SUBJECT: Preliminary Review of Proposed Subdivision Plat for the David Elliott Property, Gt. Diamond Island

TO: Chairman and Members of the Planning Board  
DATE: May 10, 1976  
FROM: Warren J. Turner, Planning Department  
SUBJECT: Preliminary Review of Great Diamond Island Shores Subdivision, Phase I

Great Diamond Shores Subdivision  
Phase I

Review of Preliminary Plat For Great Diamond  
Shores, Phase I - David L. and Diane B. Elliott,  
Owners

NICHOLAS STREET

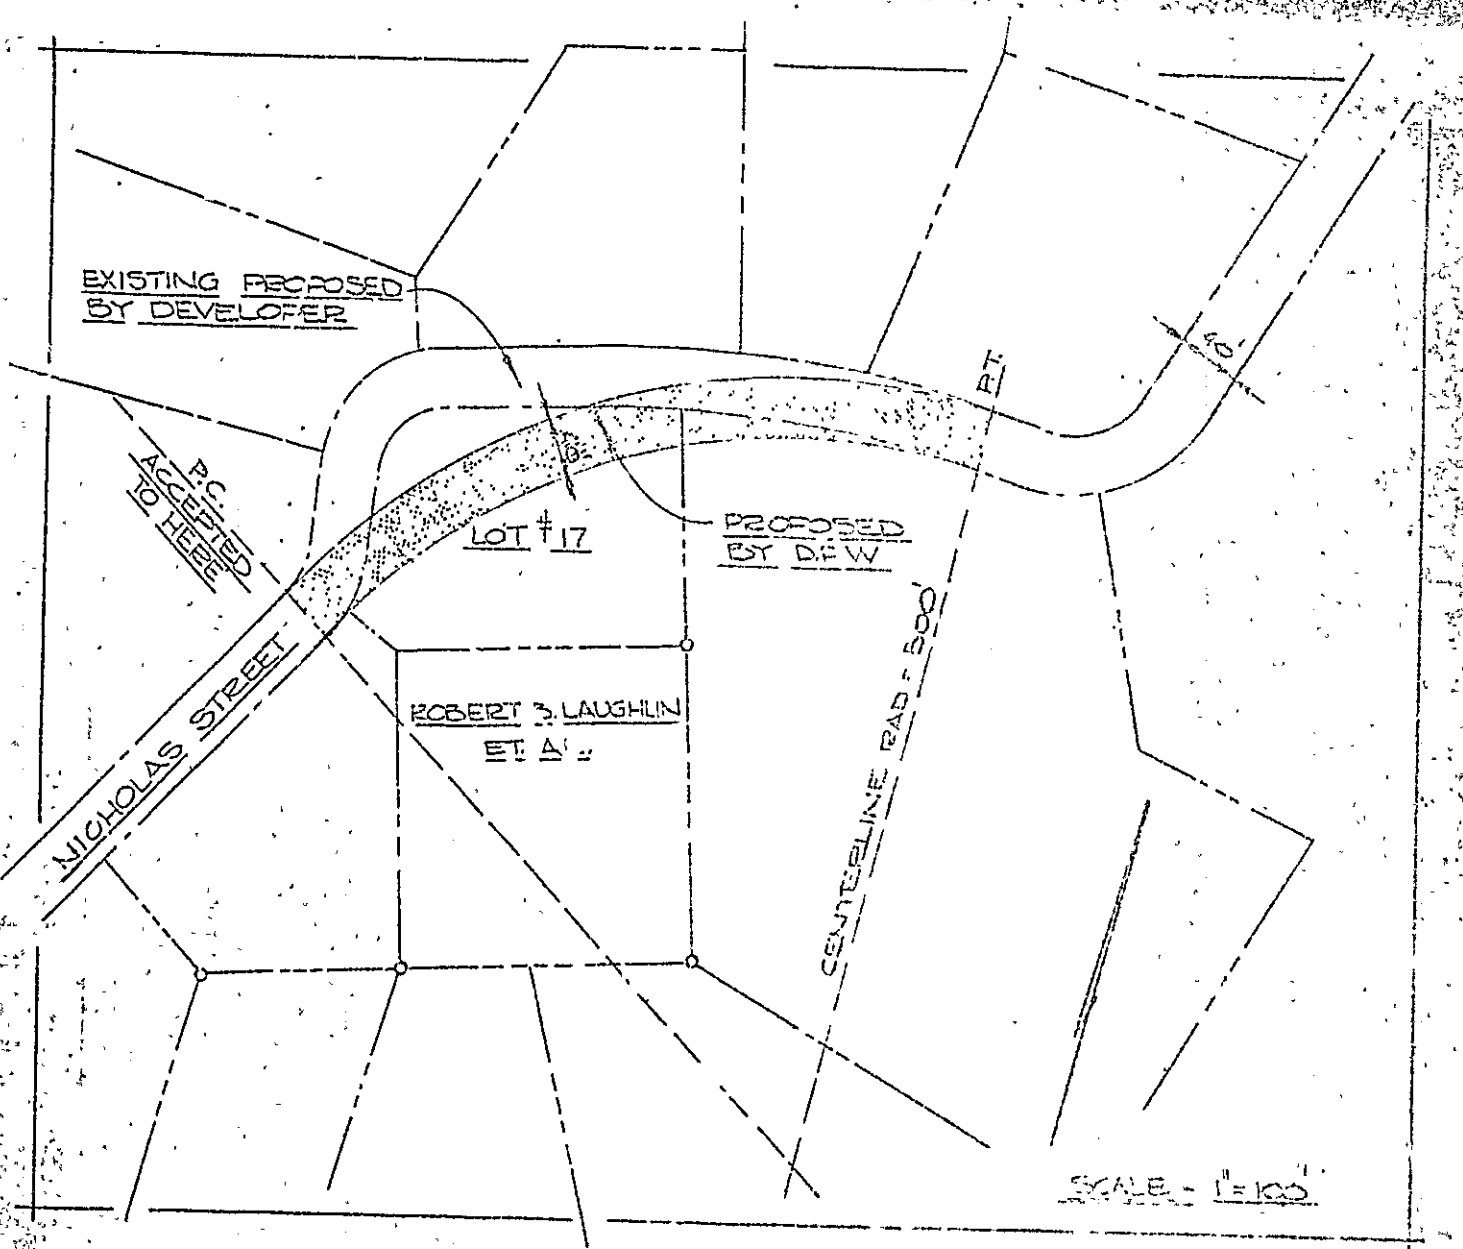
1. Typical Section of Streets: The submitted plat failed to show the typical section of the proposed streets, however, I have been in written communication with the developer's consultant concerning such, and have outlined the ordinance requirements in regards to street right-of-way widths and proposed traveled ways. We would not, therefore, disapprove this plat on this basis.
2. Inaccessibility to Existing Lot: The existing lot shown on the plat as being owned by Robert B. Laughlin, et. al., would appear to be land locked by lots #16 and #17. This Department would request the developer to consider a proposed right-of-way to be twenty feet (20') in width and to lie equally on either side of the common division line between proposed said lots #16 and #17.

1. Straighten curve and make minor fill of wet area adjacent to Lot 17.
2. Lot 1 of the Preliminary Plat may be subject to a right-of-way for a pedestrian connector now under study by the Great Diamond Island Association and the City; this pedestrian route would connect Nancy Band more directly to the Wharf and provide a more direct walkway for the residents of the Sandy Point area of the Island.

1. Access: An access easement should be shown across Lot #17 (unbuildable) in order to furnish access to the street for the 1 Acre lot owned by Robert B. Laughlin et al. The Assessors' Office records indicate that an unspecified right to passage exists for that lot by deed provision.

Yes. The final plan and the amended preliminary plat both show the portion of street affecting Lot #17 as being relocated as suggested by Mr. Rague of Public Works.

The rather sharp curve in the right-of-way for the extension of Nicholas Street has been eased by relocating the street right-of-way across Lot #17 in the preliminary plat. Lot #17 is unbuildable due to seasonal wetness.
